Application No: AB/135/20/OUT

Site Address: Land at Ford Road Arundel

Description of works: Outline application with some matters reserved (except for access) for the development of 90 dwellings & associated amenity land. This application is a Departure from the Development Plan, affects the setting of listed buildings & affects the character & appearance of the Arundel Conservation Area.

Thank you for your internet representation made on 2nd January 2021 which has been recorded as an objection with the comments as follows:

Parameter Plan - Green and Blue Infrastructure

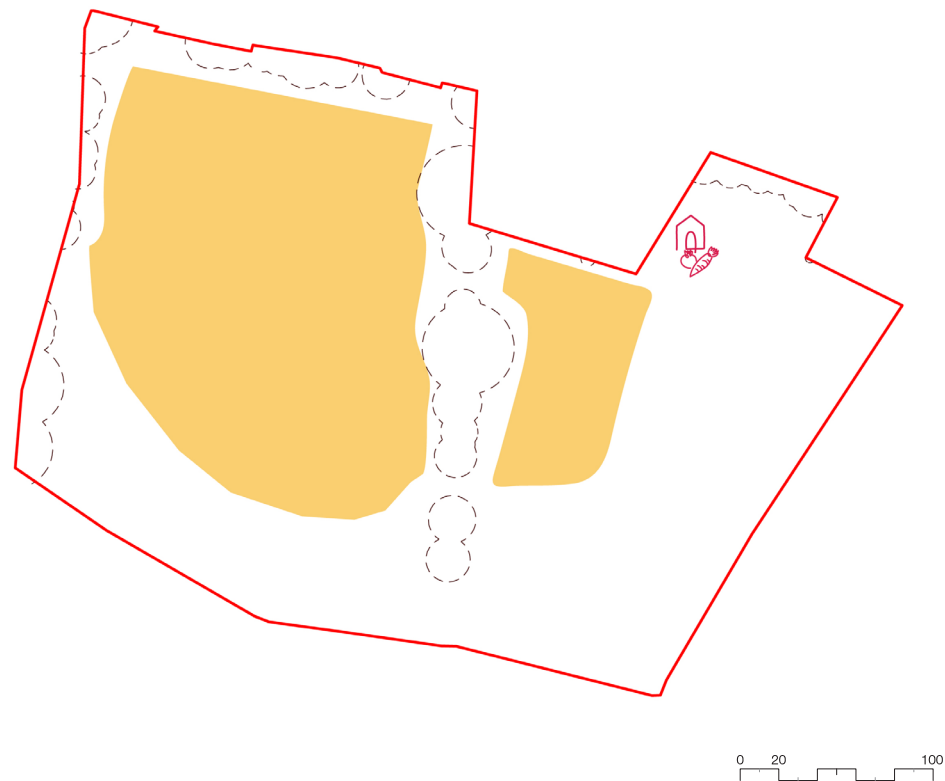
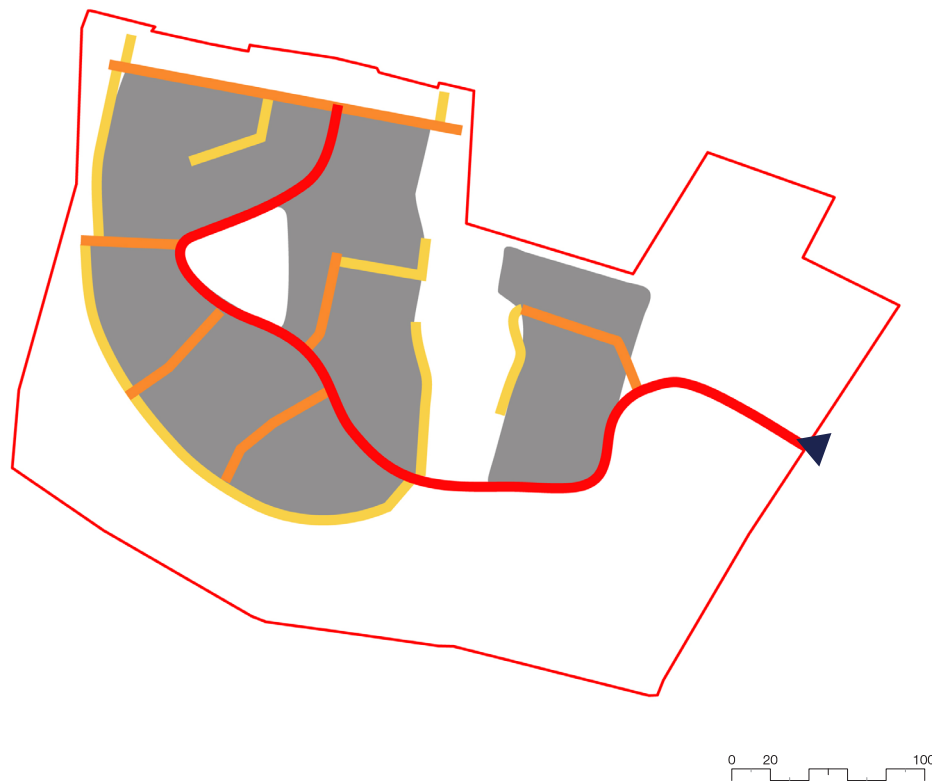
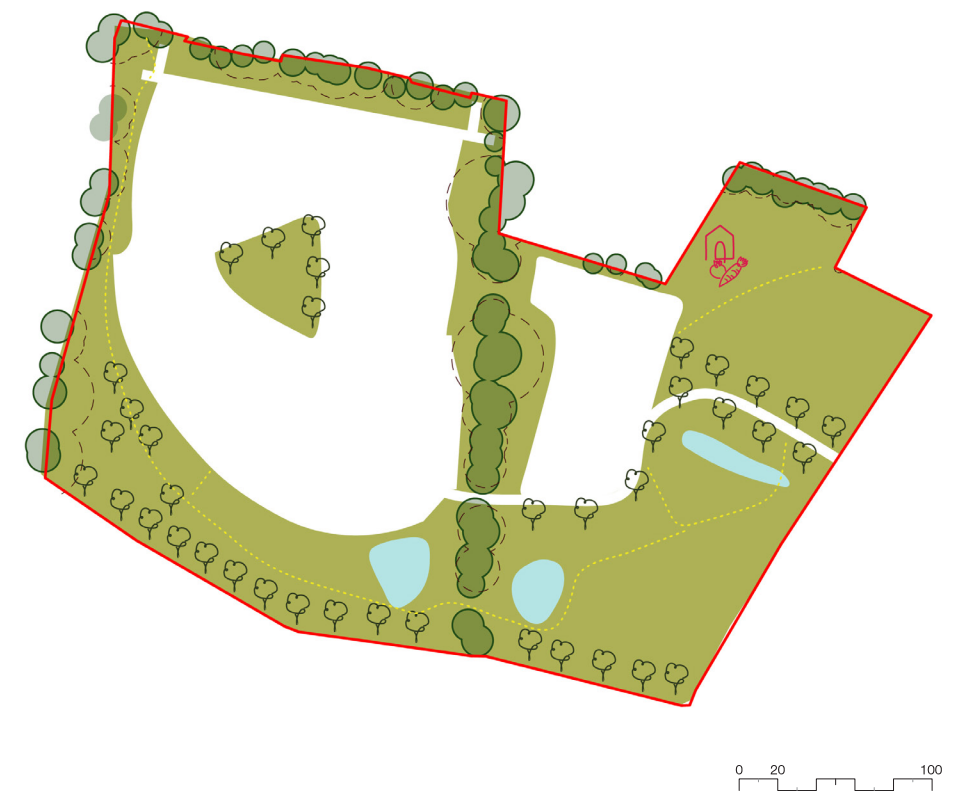
cont/... (4) ensuring the provision of new planting of appropriate species to minimise the impact on the rural ambience of the area and to screen the development. A much denser line of planting along the eastern boundary of the residential development than that implied on the illustrative master plan will be needed in order to effectively screen the houses from Ford Road and other public viewpoints further east.
